DECISION DELEGATED TO HEAD OF PLANNING

Application No:	H16-0410-23	Applicant:	Mrs F T Mir Javadi
Proposal:	Change of use of residential dwelling to HMO - re-submission of H16-1111-22		
Location:	106 Halmer Gate Spalding		
Terminal Date:	23rd June 2023

J175-PL1C

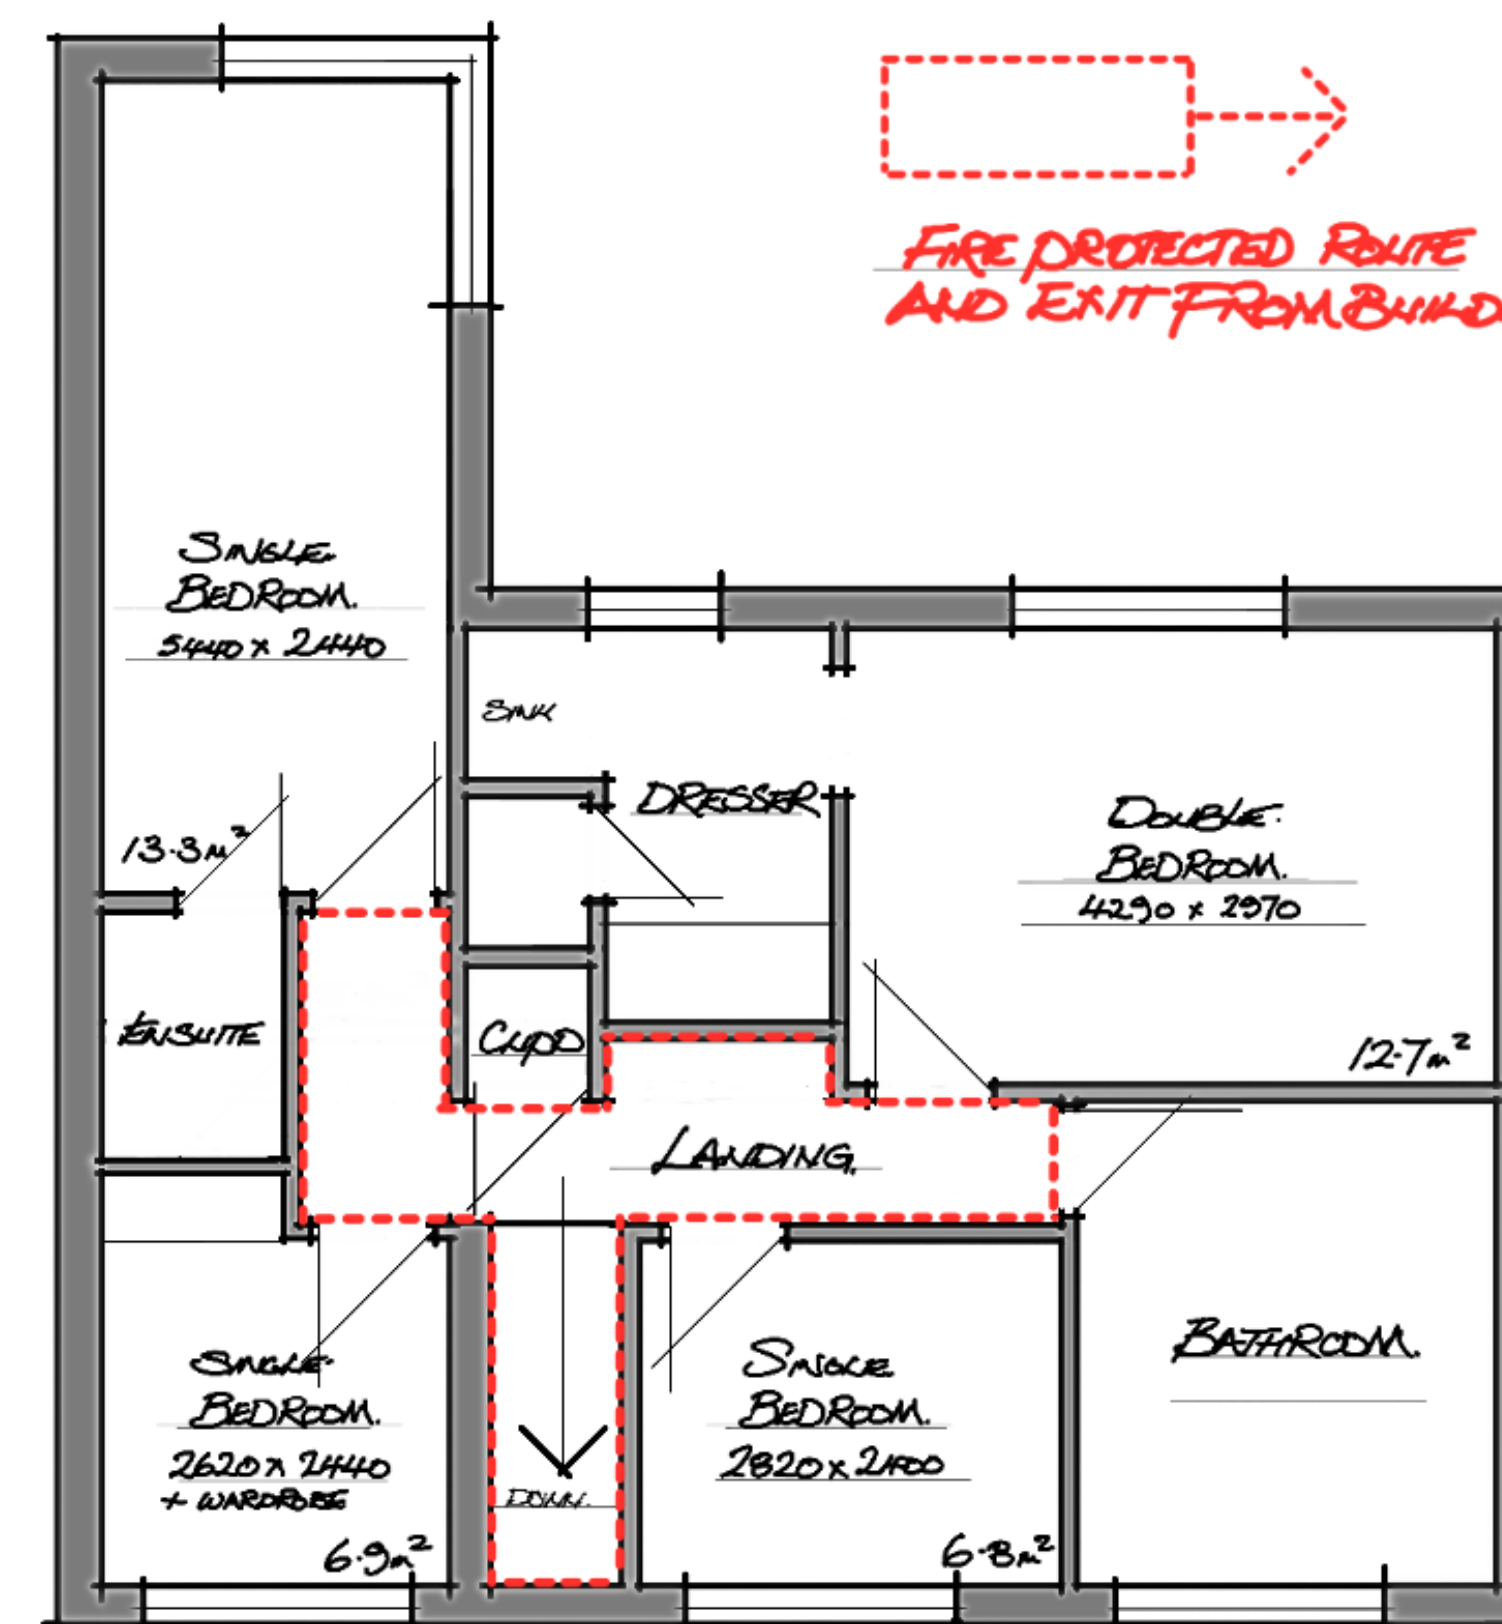
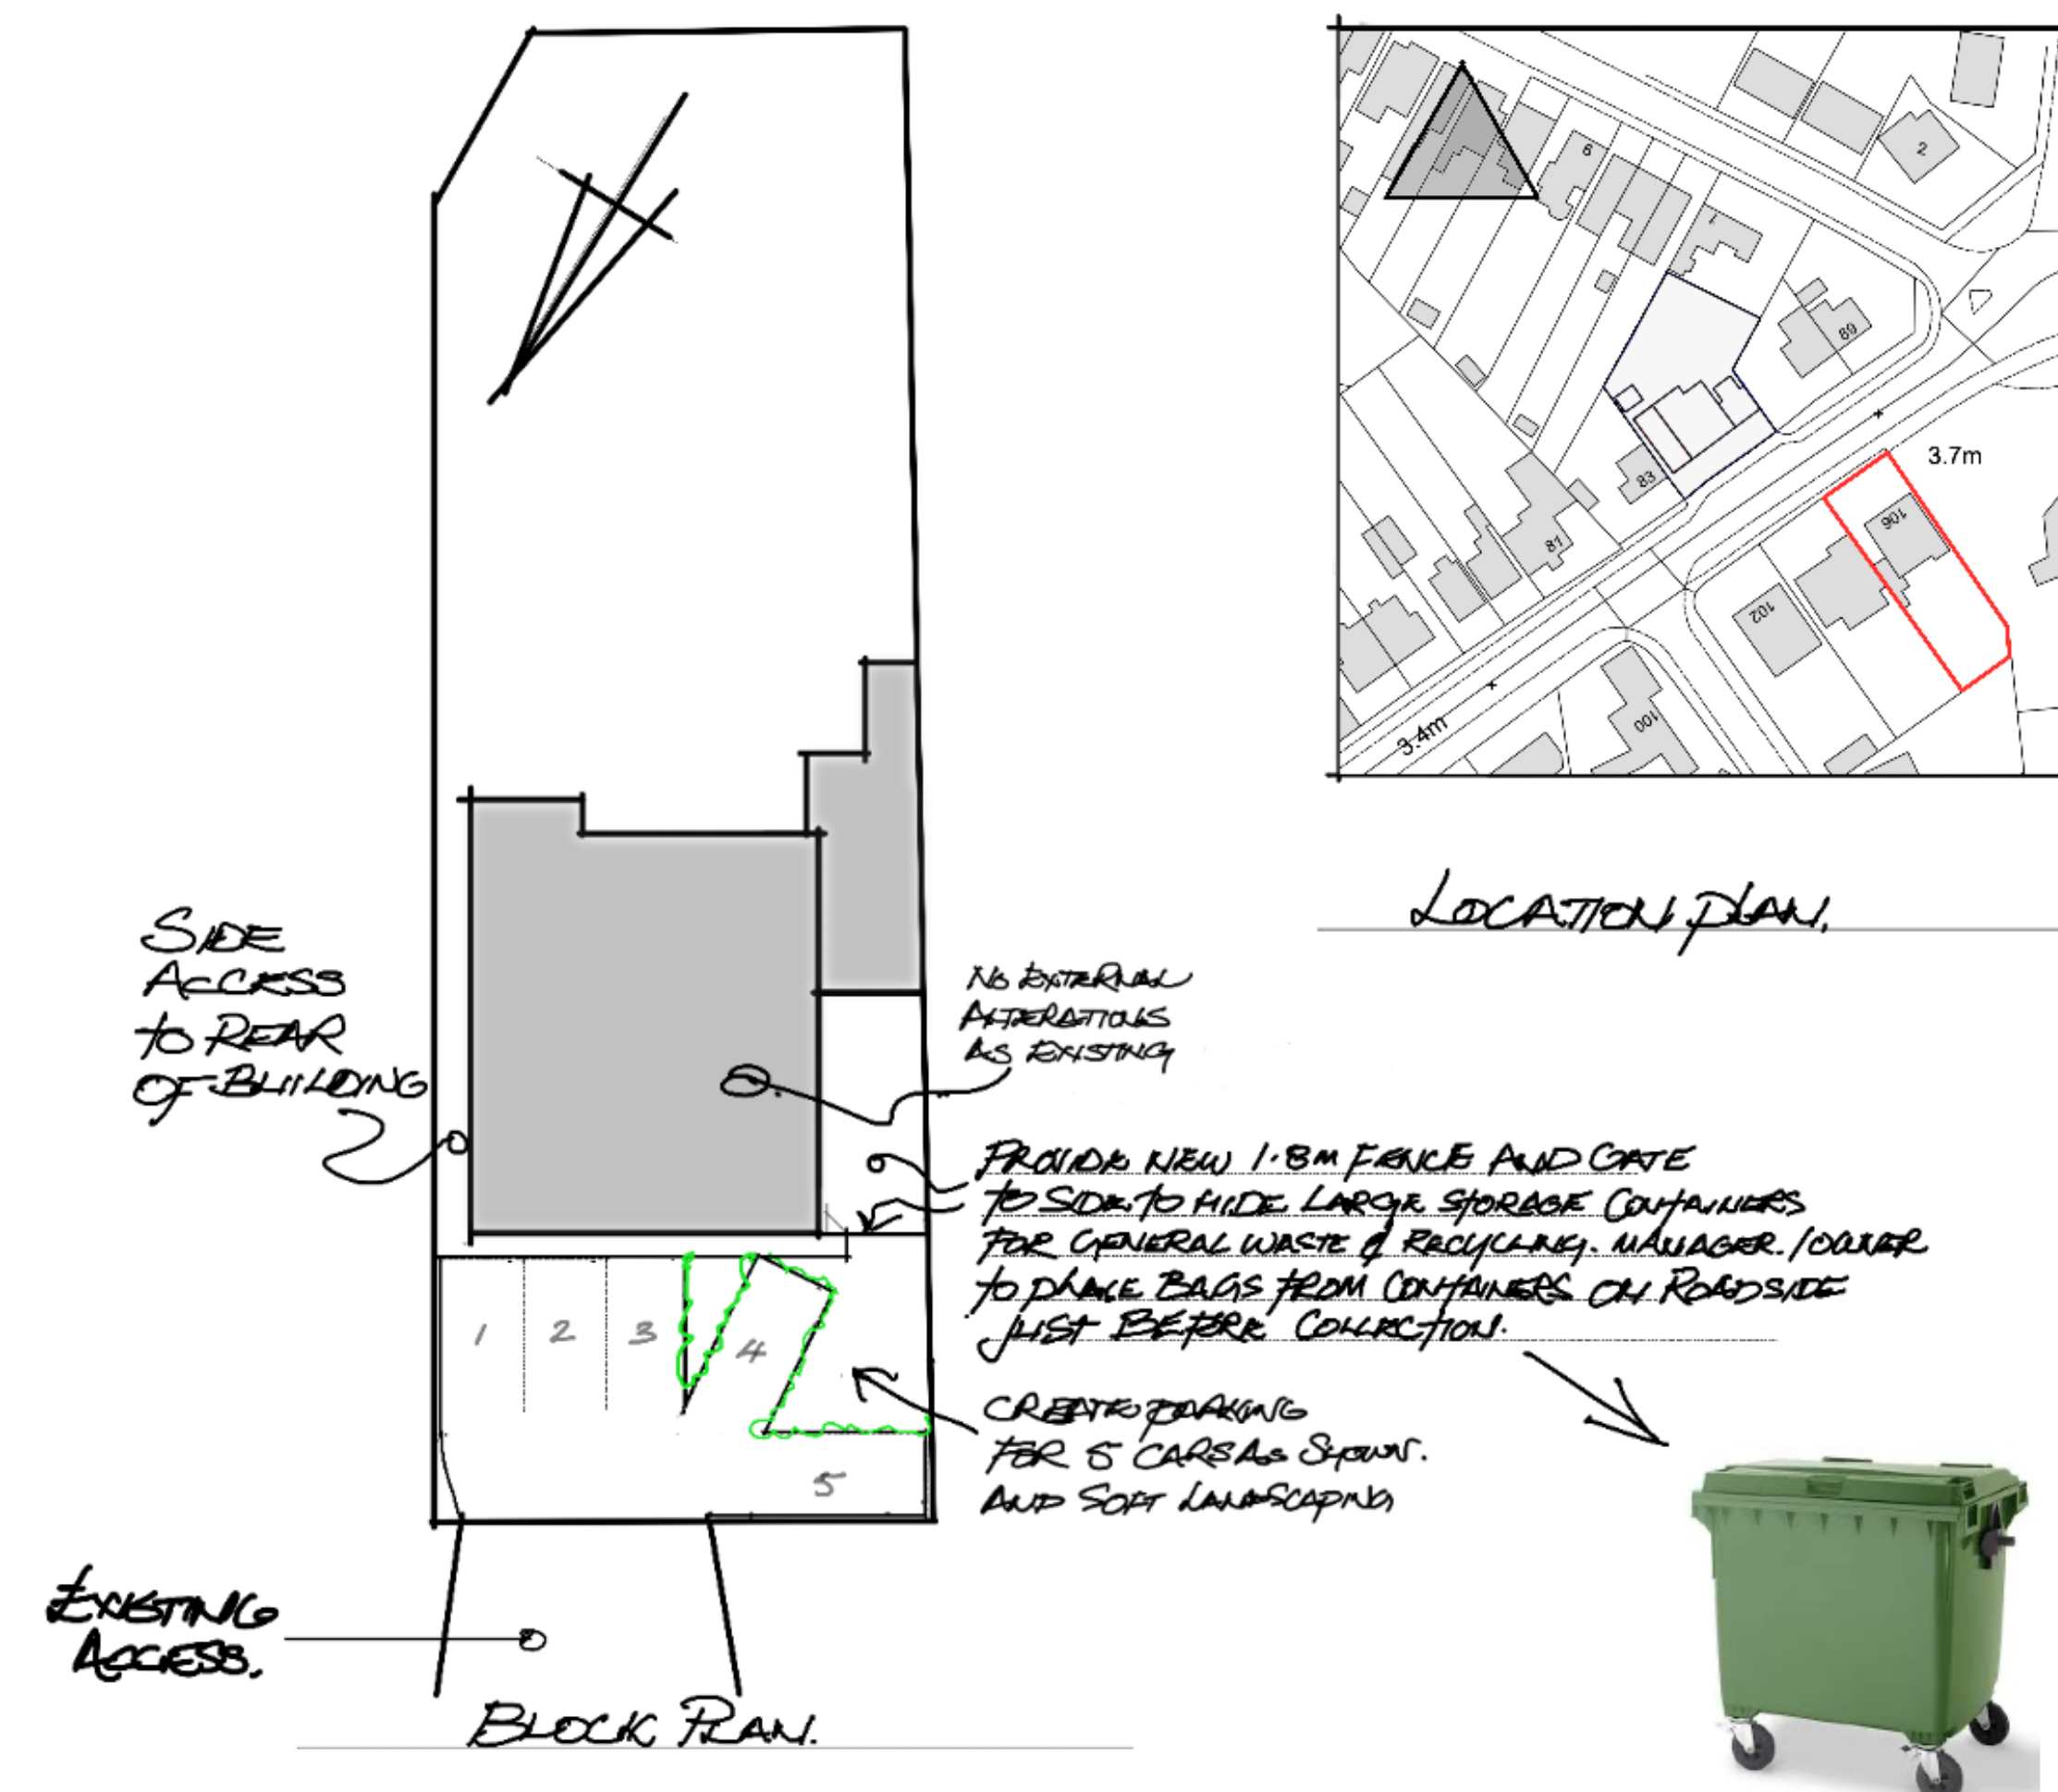
3. The proposal would not materially alter the historic or natural environment or general character of the area.
4. Provisions have been made to accommodate refuse in two large receptacles to the east of the dwelling, one for recycling and one for general refuse. This is an improvement on the previous scheme. As the receptacles will have lids, the potential for pests and noise is low.
5. There are no defined parking standards for HMOs in the Local Plan. It is proposed that five parking spaces would be provided, and that future occupants would be vetted to ensure no more than five vehicles are present. Five parking spaces is woefully insufficient for a property that would have seven or more occupants and no provisions for on street parking. A lack of off-street parking may damage the safety of highway users or the access of other residents.

The property is located close to the mini roundabout at the conjunction of four roads. Therefore, occupiers may have difficulty with pulling onto the road due to its business and a lack of visibility. This concern is compounded by a lack of turning space on the property, meaning it is possible that residents would have to reverse out onto Halmer Gate. Naturally, this is dangerous and unacceptable.

7.There is a small communal living room and kitchen proposed. While the addition of a living room is an improvement over the previous scheme, one living room and kitchen is insufficient for seven plus people and would lead to residents primarily using either outdoors or their rooms as amenity space. If the outdoor space is favoured, the potential for noise pollution would increase further. If the bedrooms are favoured as amenity space, there may be a detrimental impact on the mental health of residents.

Similarly, there are only two communal bathrooms and one ensuite. It can be assumed the ensuite bathroom would only be used by the occupant of the relevant bedroom. Therefore, there would be two bathrooms between at least six people. Again, this is not an ideal situation.

While there has been a new double bedroom created, the majority of proposed room sizes are extremely small. This will not be conducive to well-being.

The property is within Flood Zone 3. It is within the "Danger for All" hazard category within the local Strategic Flood Risk Assessment, with flood depth expected to reach 2 metres. The proposal would add bedrooms to the ground floor, bedrooms that would be severely at risk of flooding. As HMOs are often occupied by the most vulnerable members of society, the impact of flooding would be felt particularly severely on this site.

As discussed above, the proposed parking arrangements are unacceptable. Five spaces are provided, however, the spaces marked four and five would be extremely difficult to park in. It is expected that there would be up to nine residents, each potentially needing a vehicle, potentially leading to a deficit of four spaces.

No turning space would be provided, potentially resulting in occupiers reversing onto a busy road, on a bend.
